City of Albuquerque Development Review Board
Submitted on: December 2, 2016

Project No. 1005354
16EPC-40059 - Amend Site Development Plan for Building Permit
16EPC-40060 - Amend Site Development Plan for Subdivision

**Final Sign-off for EPC-approved
Amended Site Development Plan for Subdivision and Building Permit
Sawmill Village Redevelopment - Phase 2
Tract 2-D-1 of ARBOLERA DE VIDA, Unit 2B
(To subdivide into Tract 2-D-1A and 2-D-1B)**

SDP-5.1 V3

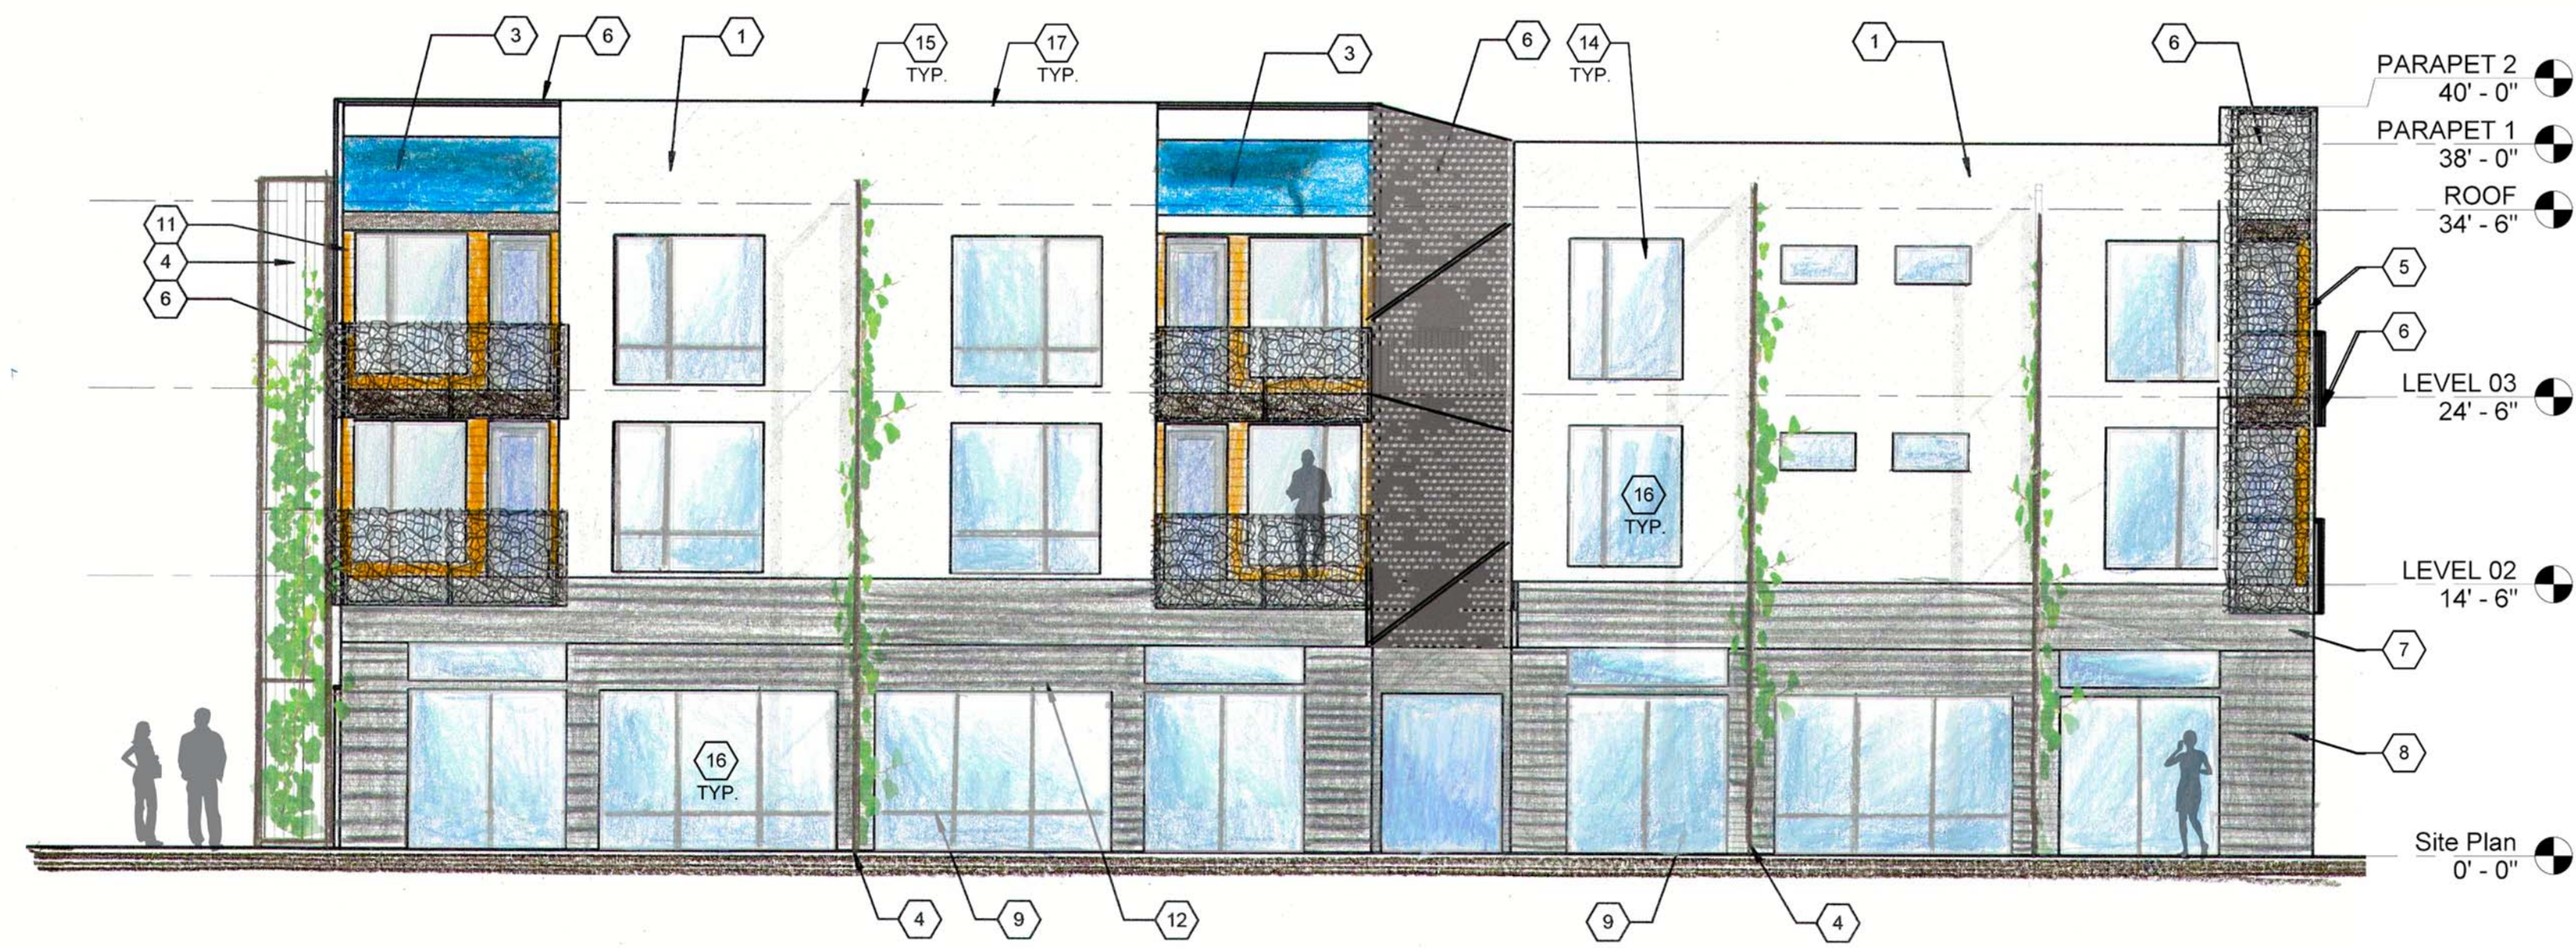
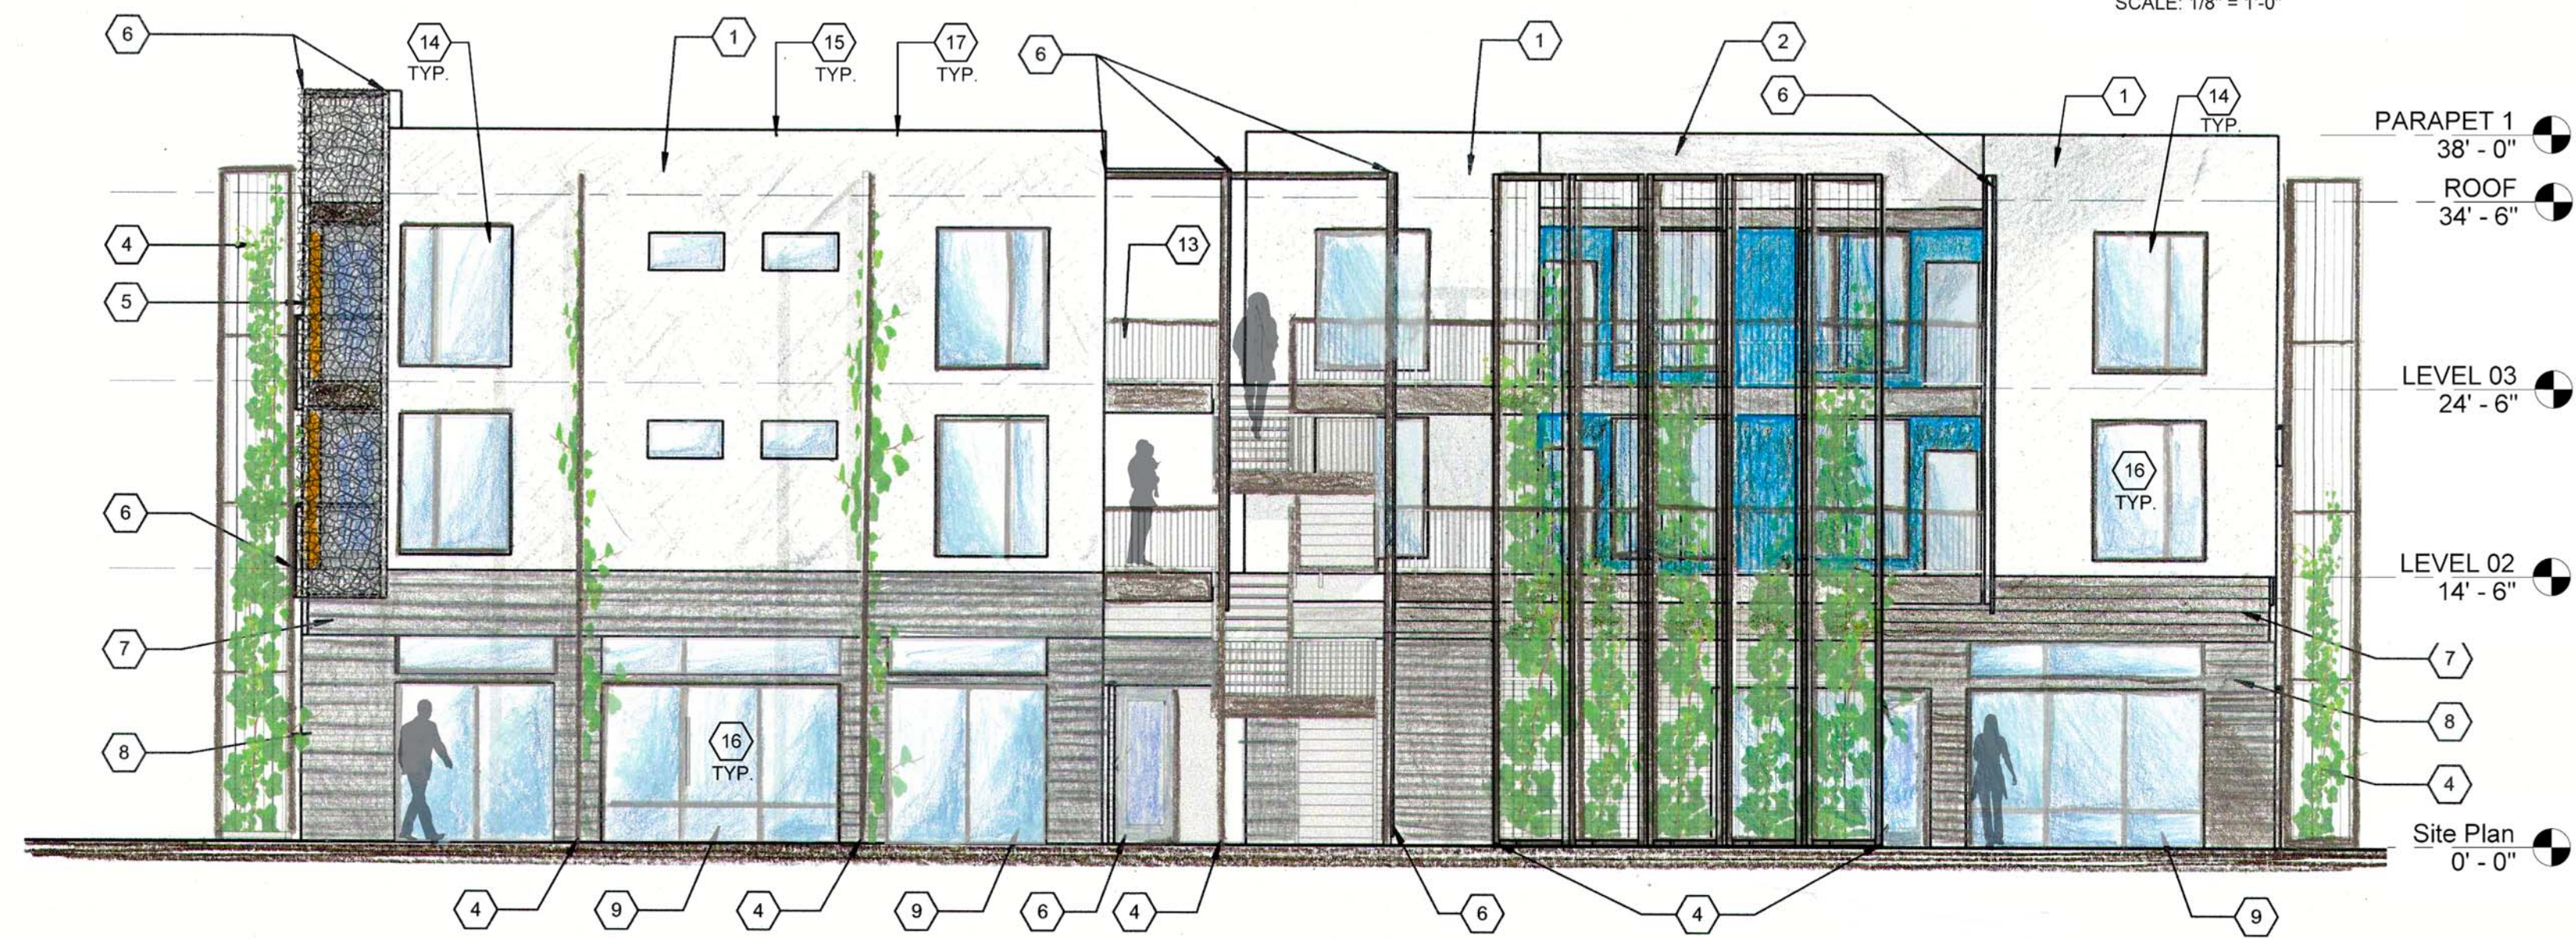
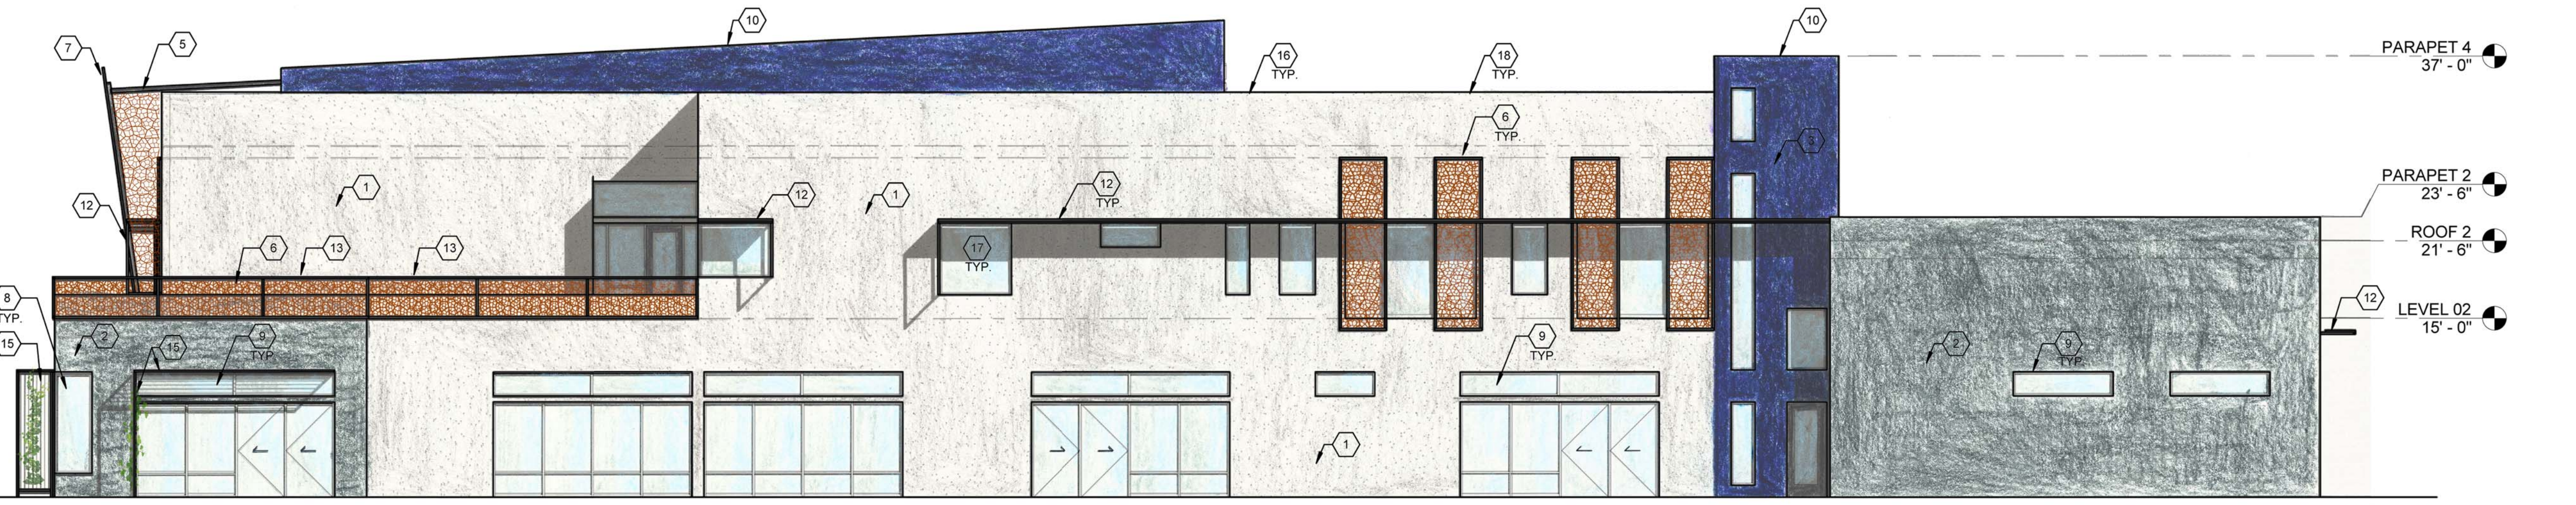
- A. *A note shall be added to the elevations to indicate that mechanical and electrical equipment shall be screened from public view (Regulation 4.d).*

- B. *A note shall be added to the elevations to indicate that reflective glass is prohibited (Regulation 4.f).*

A. *The accent material of the buildings will be specified as stained cement panels to be consistent with the materials used in Sawmill Village (Exterior Wall Materials and Colors section).*

B. *A note needs to be added to the elevations to indicate that roofs will be a low heat absorbing single-ply material in a light color (Roof Materials and Colors section).*

Refer to Note 15 on Sheets SDP 5.0 and SDP 5.1 as well as Note 16 on Sheets SDP 5.2 and SDP 5.3 regarding roof-mounted mechanical and electrical equipment.

Refer to Note 16 on Sheets SDP 5.0 and SDP 5.1 as well as Note 17 on Sheets SDP 5.2 and SDP 5.3 regarding reflective glass.

Refer to Note 7 on Sheets SDP 5.0 and SDP 5.1 for specified stained cement panel material locations.

Refer to Note 17 on Sheets SDP 5.0 and SDP 5.1 and Note 18 on Sheets SDP 5.2 and SDP 5.3 regarding low-heat absorbing materials.
